Application No: Y/36/22/HH

Site Address: Berri Court Main Road Yapton BN18 0ED

Description of works: Erection of detached workshop, gym/hobby and greenhouse. This application affects character and appearance of the Main Road/Church Road Yapton Conservation Area and a Listed Building.

Response to Y/36/22/HH

Date	Drawn	Scale	Checked
FEB 22	SR	as noted @ A1	-
Job Number	Drawing Number	Revision	
BR-497.22	-05	-

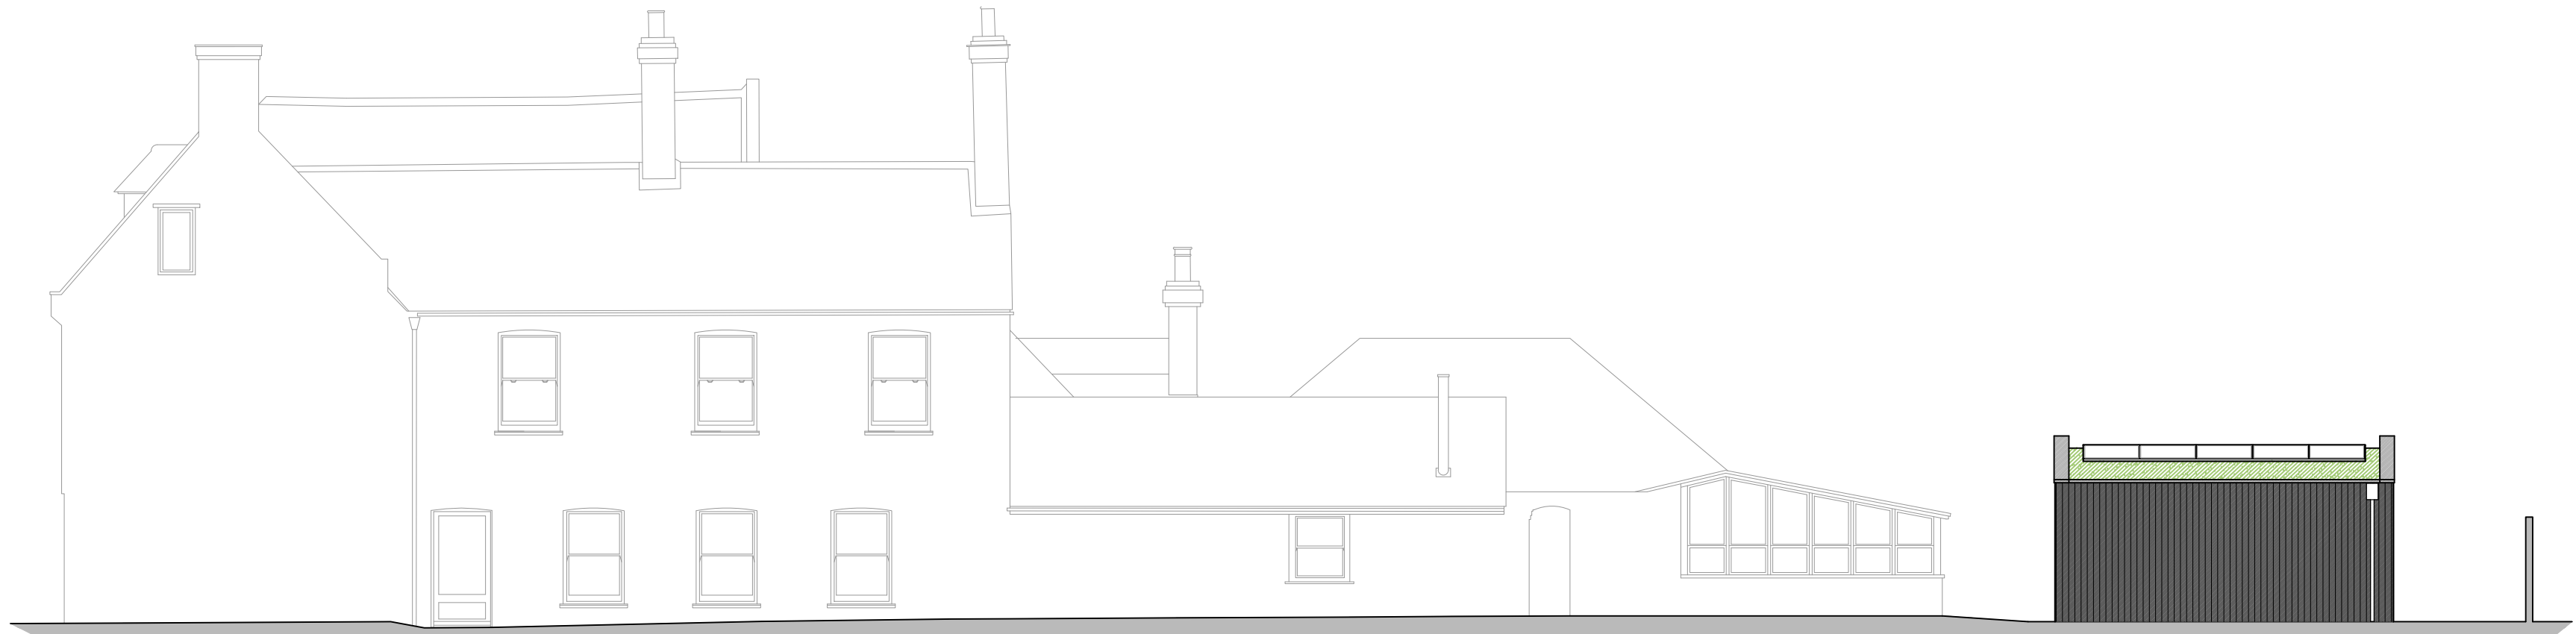
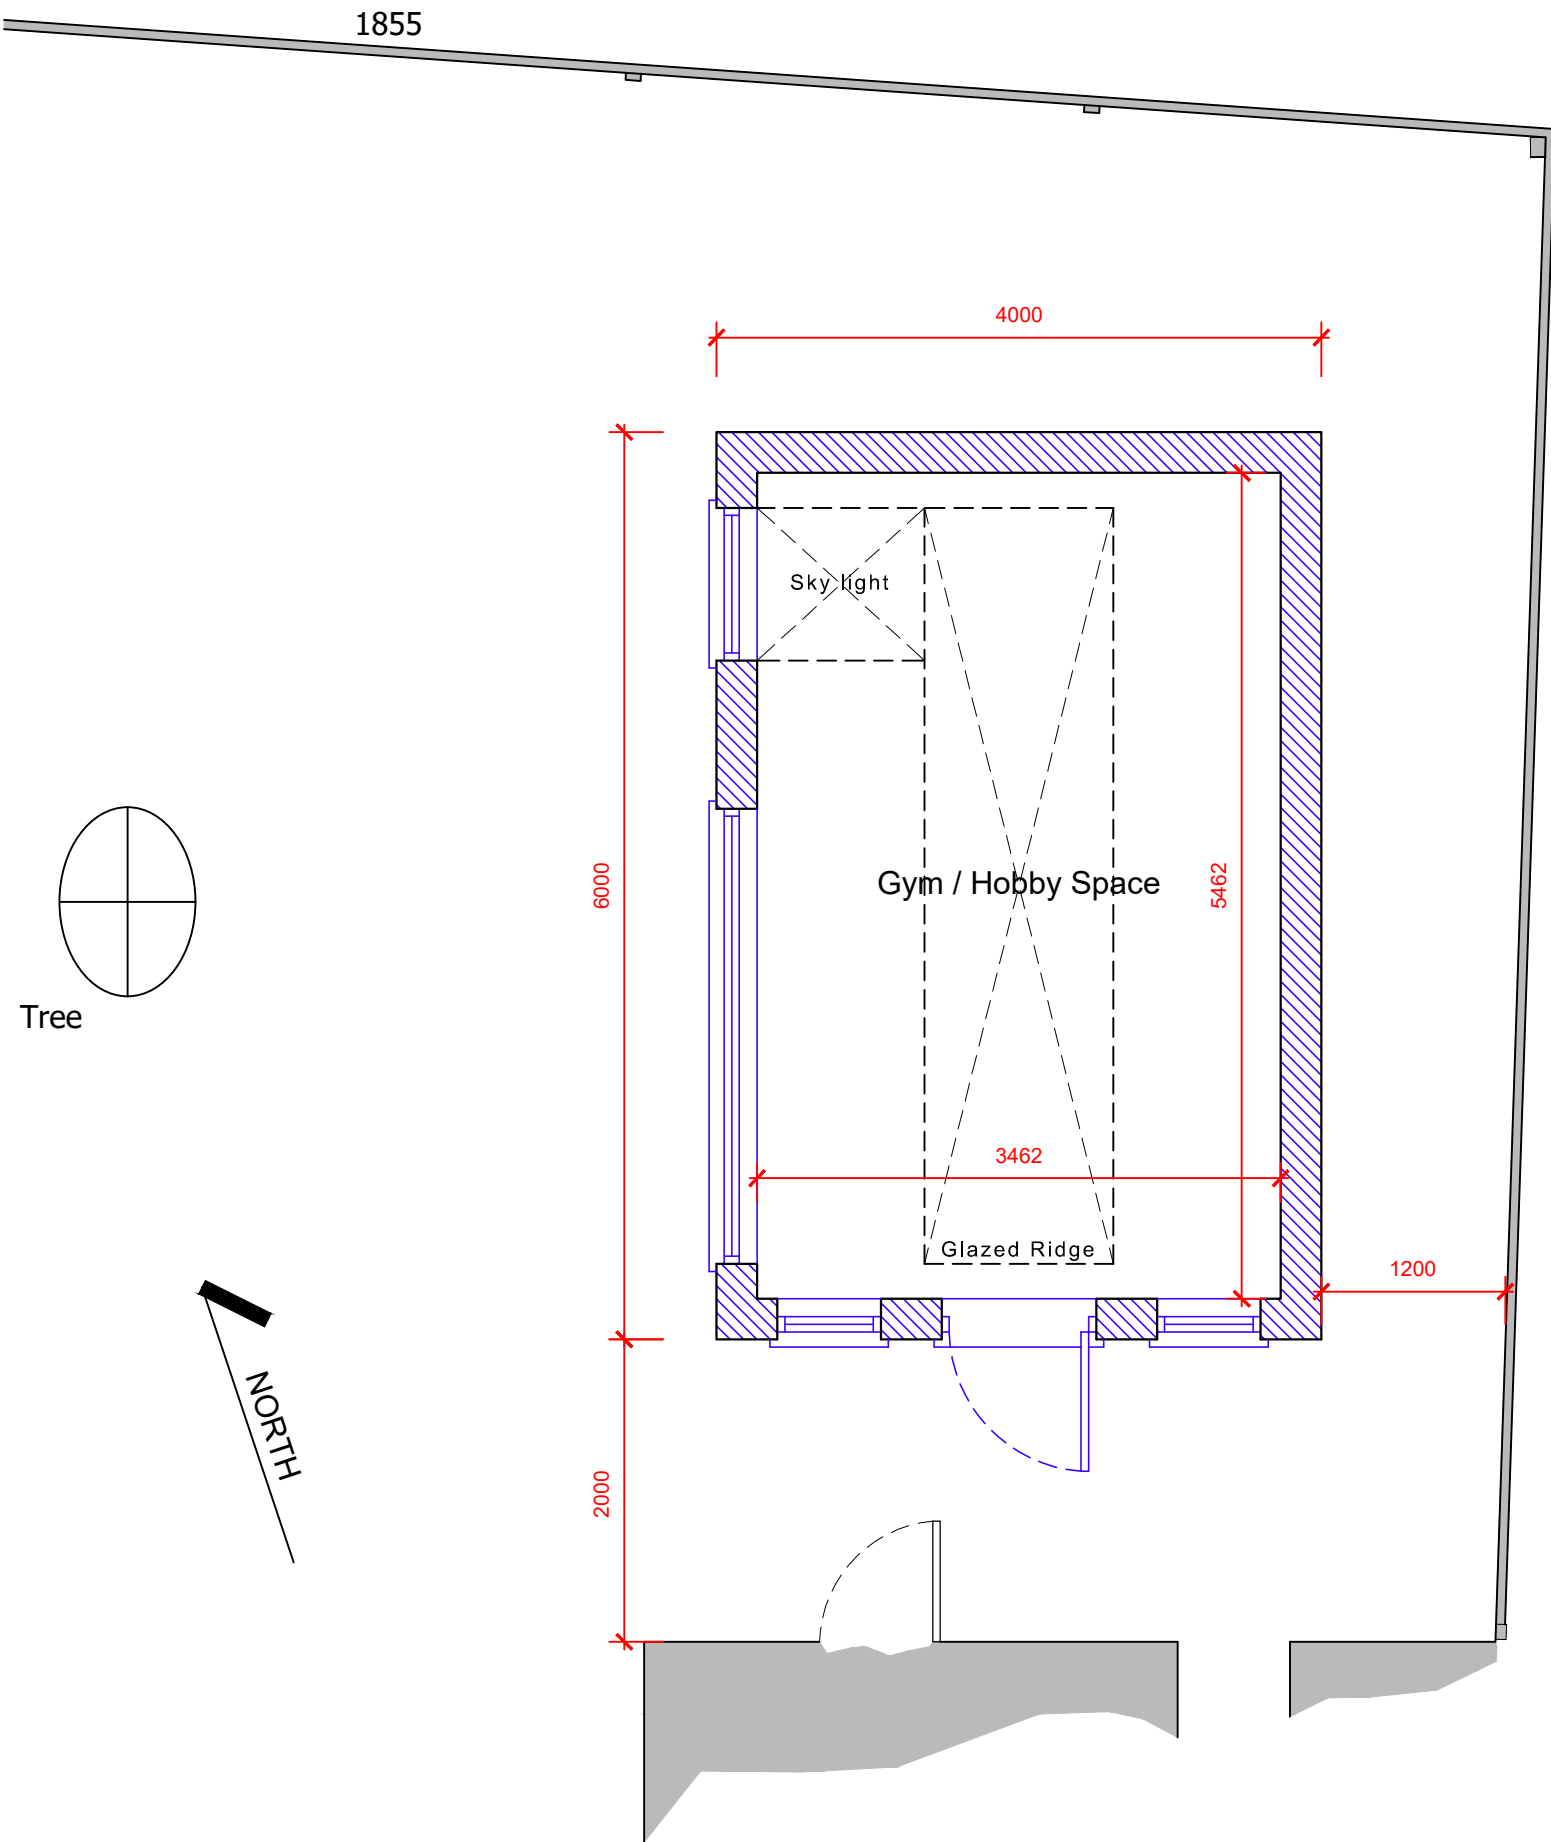
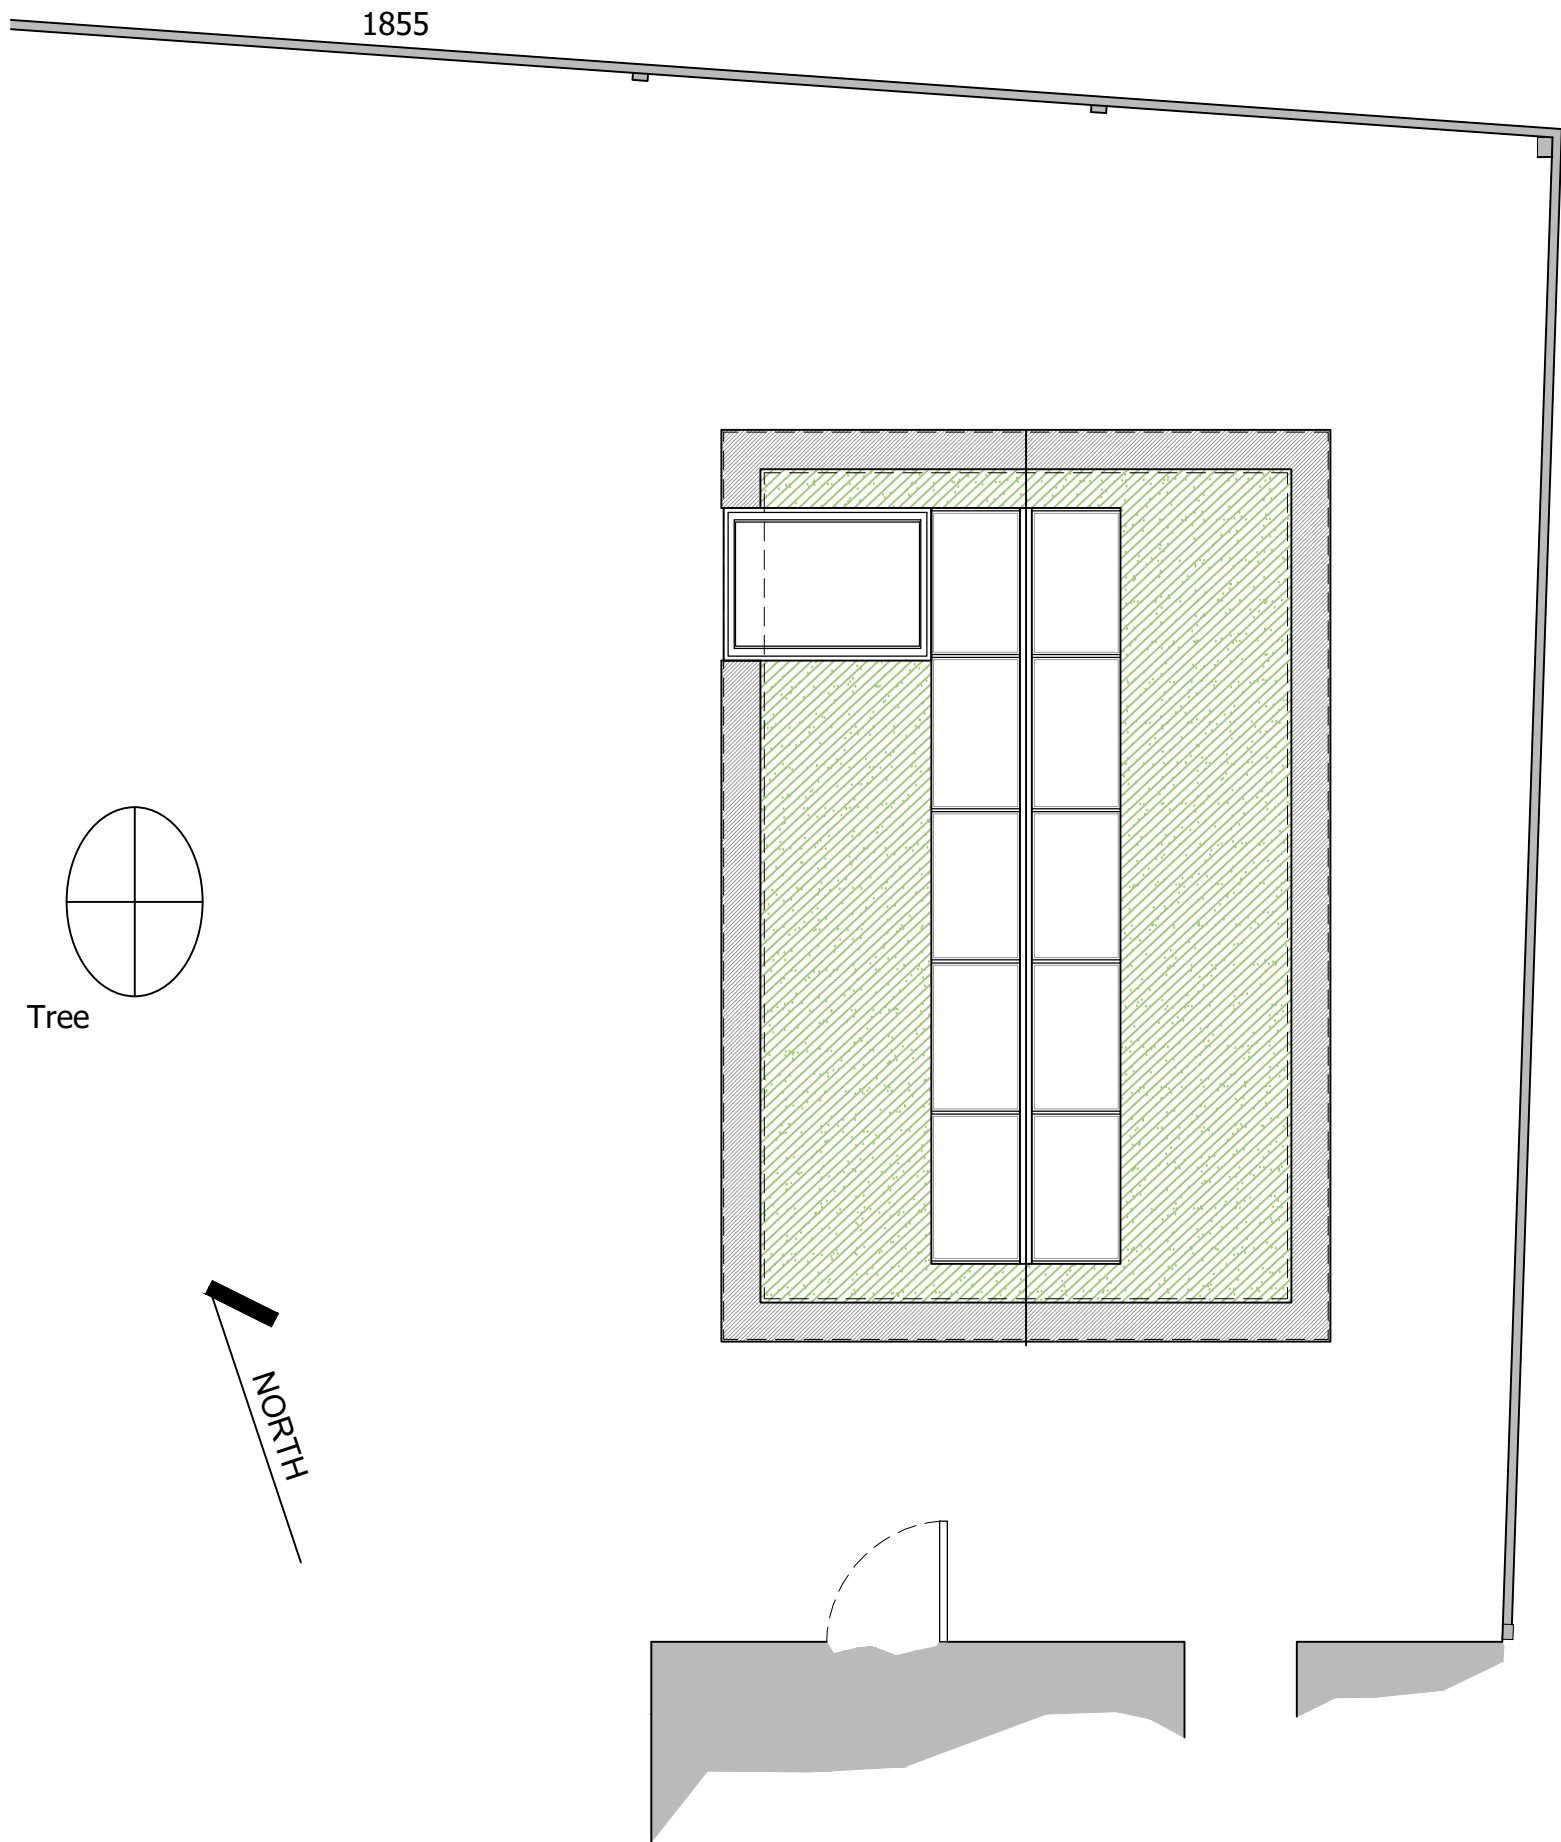
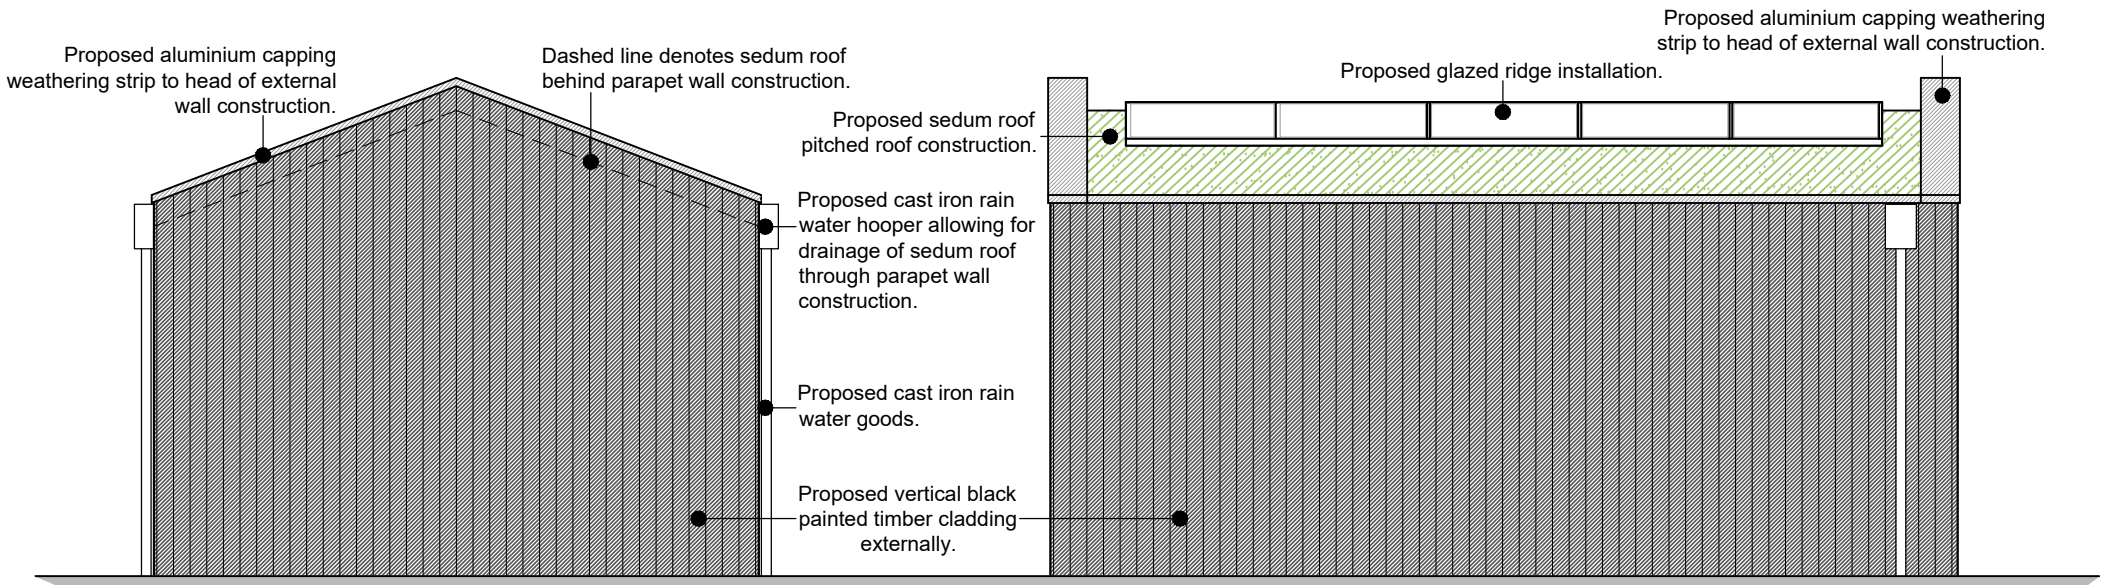
3. Proposed gym/hobby room (drawings BR/497/05) - The proposed building is identical to the proposed workshop. Whilst to the back of the Berri Court the proposed building is sited within an interesting historical

backdrop to the listed building. YPC believe that the proposed unit must be more reflective of the character and heritage of Berri Court. YPC would also expect an additional outbuilding in this area to relate more closely with the main dwelling. It should also be noted that due to level differences this proposed building will stand higher than the proposed workshop thus having a wider impact on the wider conservation area and adjoining properties.
